5-9 Cowan Road St Ives SSDA Landscape Report - Response to Submissions

Prepared for Prosper
June 2026

DPHI Comments to RtS

Drawing No.	Drawing Name
L-401	Softworks Plan 1 Groundfloor

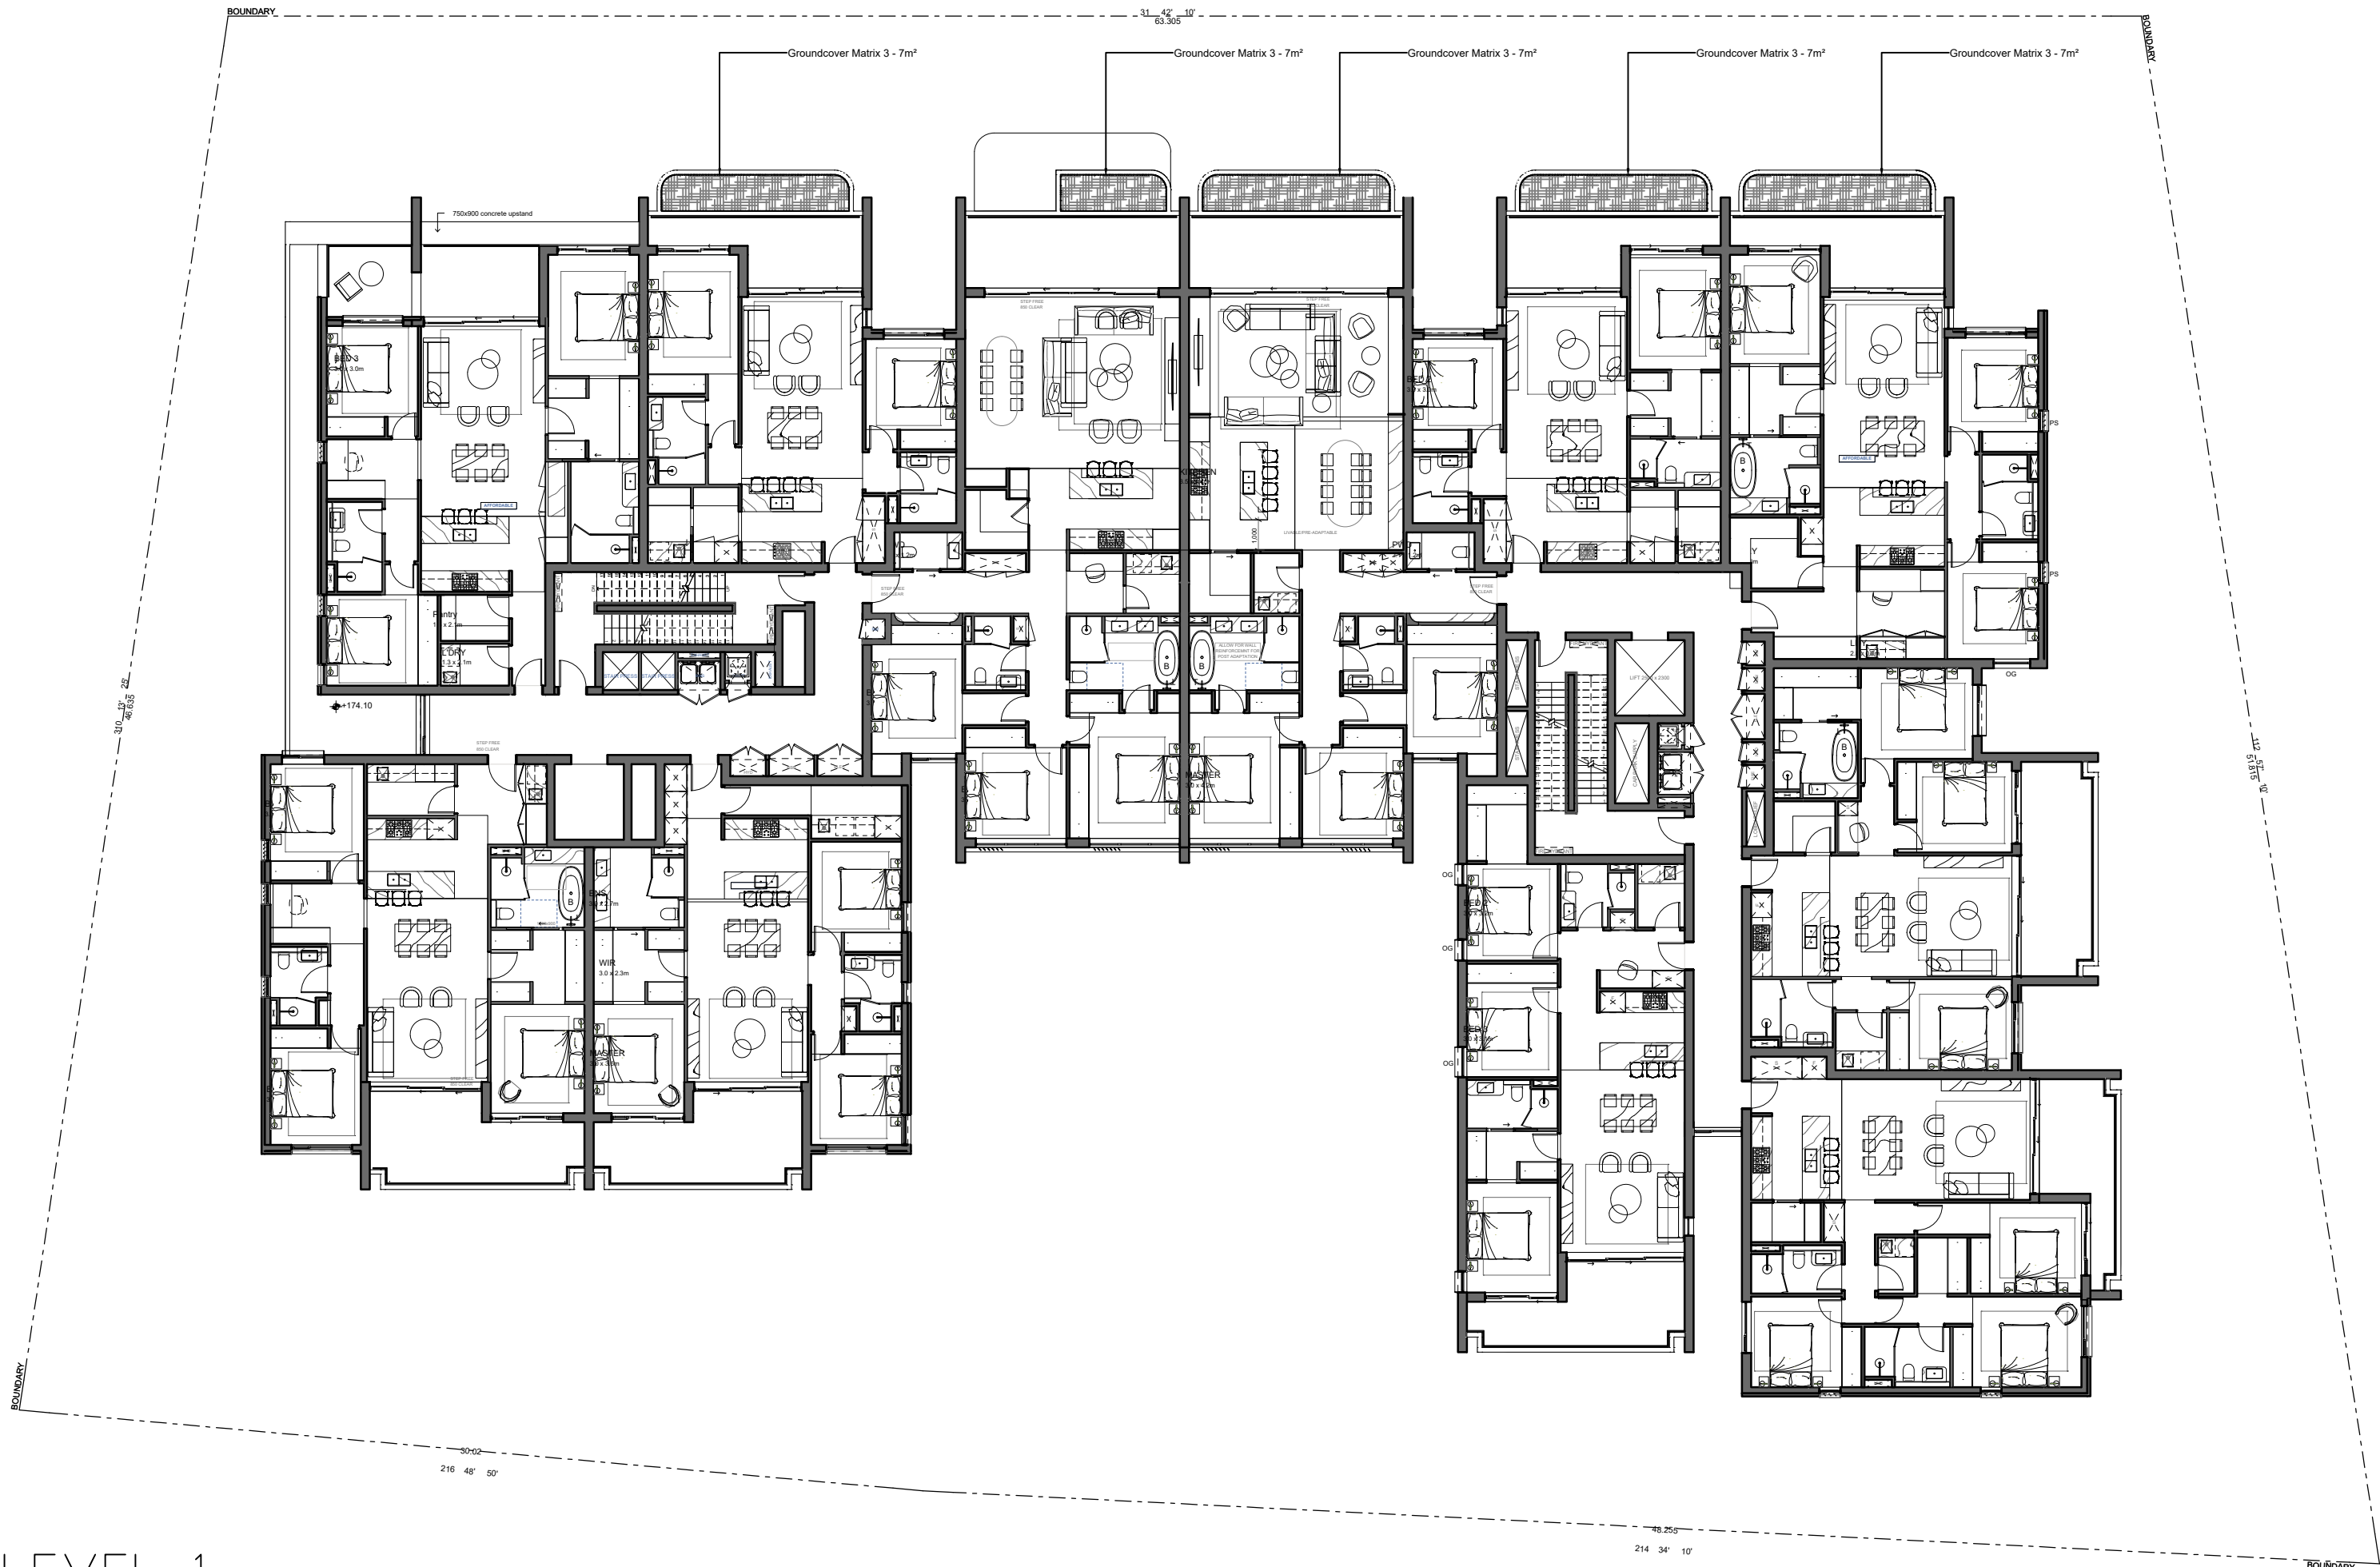
Only trees 16 and 24 are proposed to retained. Trees 2, 15, 18 and 19 are still proposed to be removed.

Revise proposed landscape planting within the sight triangles adjacent to the driveway to increase pedestrian safety. Amend the traffic report to confirm no issues with plant species selected in the sight triangles.

Revise the ground floor architectural plans against the landscape plan, as there is inconsistency between the location of paving, decking and landscaped area.

Arcadia Comments: The proposal has been revised to retain four of the six trees originally identified for removal, being T15, T16, T18 and T24, which together maintain continuity of canopy cover and streetscape character.

Two of the six trees are indentified for removal - T2 *Lophostemon confertus* (Brush Box) and T19 *Melaleuca myrtifolia* (Sweet scented Paperbark).

T2 is located within the proposed building footprint and conflicts with substation location. Retention is not feasible. It is proposed to be removed and replaced with a Turpentine (*Syncarpia glomulifera*), a locally native species that thrives in a similar growth habitat and contributes to the desired long-term streetscape canopy.

T19 is located within the proposed building footprint and conflicts with the new fire sprinkler and hydrant booster infrastructure. Retention is not feasible due to very limited space for the new essential services along the street interface. Its removal will have minimal impact on the established street character or overall canopy structure. It will be replaced with a Lilly Pilly (*Acmena smithii*).

Arcadia Comments: Planting adjacent to the driveway was reviewed. Planting within the sight triangle has been removed to maintain clear sightlines and improve pedestrian safety and visibility.

Dianella caerulea (DC) is proposed outside the driveway sight triangle, as it typically grows to approximately 500mm in height and is suitable for maintaining visibility requirements. Its character also complements the landscape setting and arrival experience at the entry.

Arcadia Comments: The ground floor architectural plans and landscape plans have been coordinated and updated to ensure full consistency in the location and extent of paving, decking and landscaped areas across all documentation.
